Our Ref: EG/15/13/

5th April 2013

Application for Householder Planning Permission

Development Dropped kerb and driveway to front of property
Location 20 Gospond Road Barnham Bognor Regis

Drg No.: 6714/01A

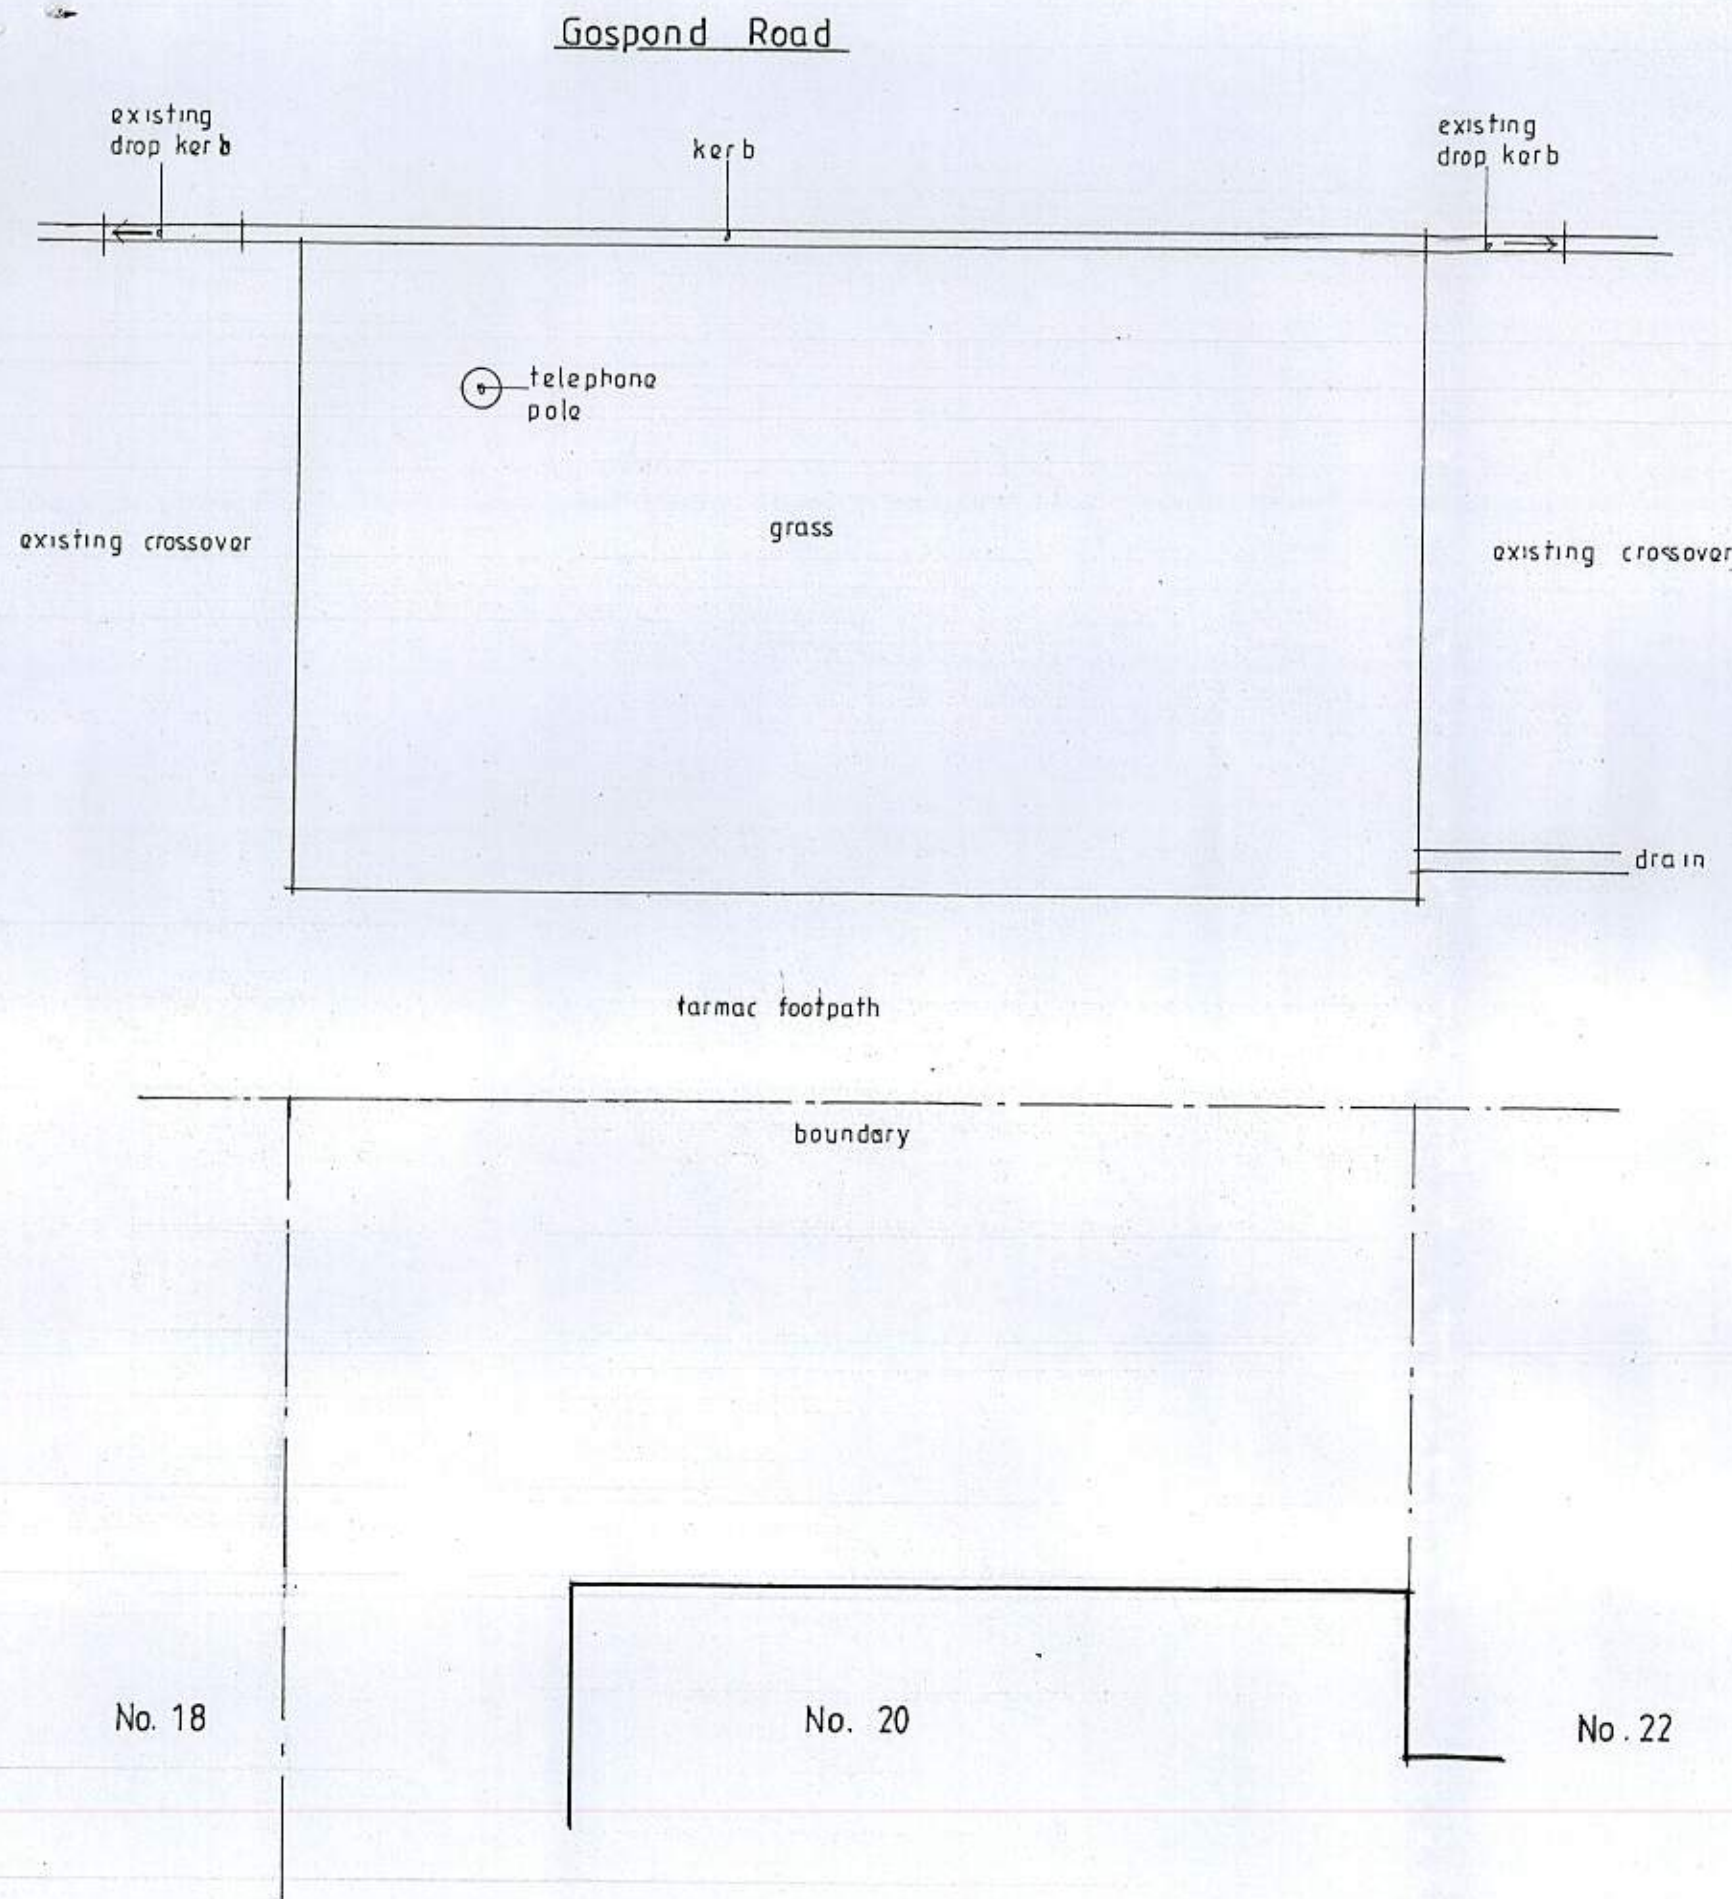
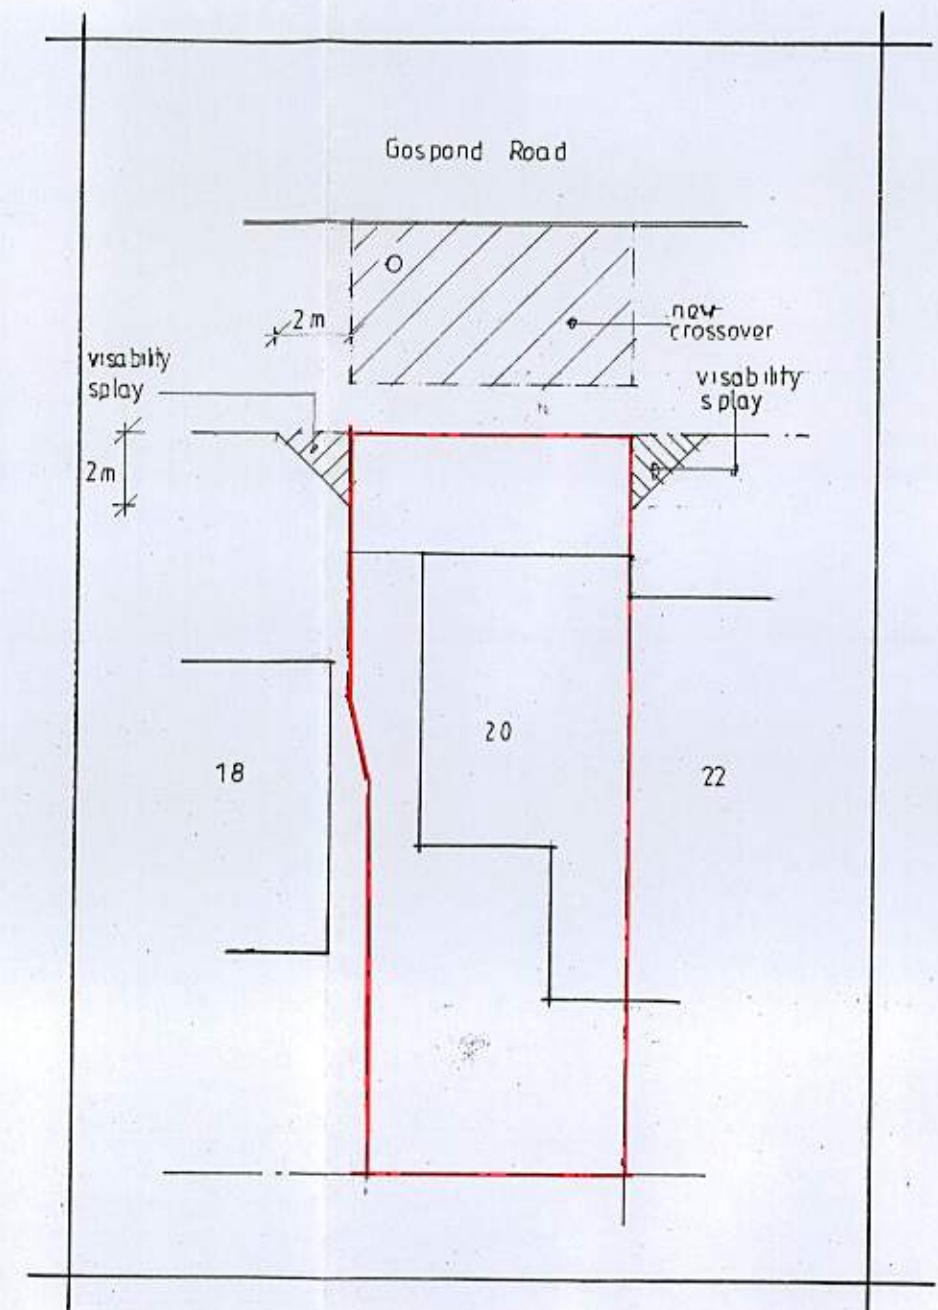
Please clearly show the visibility splays, if you require further advice on this then please contact West Sussex Highways department.
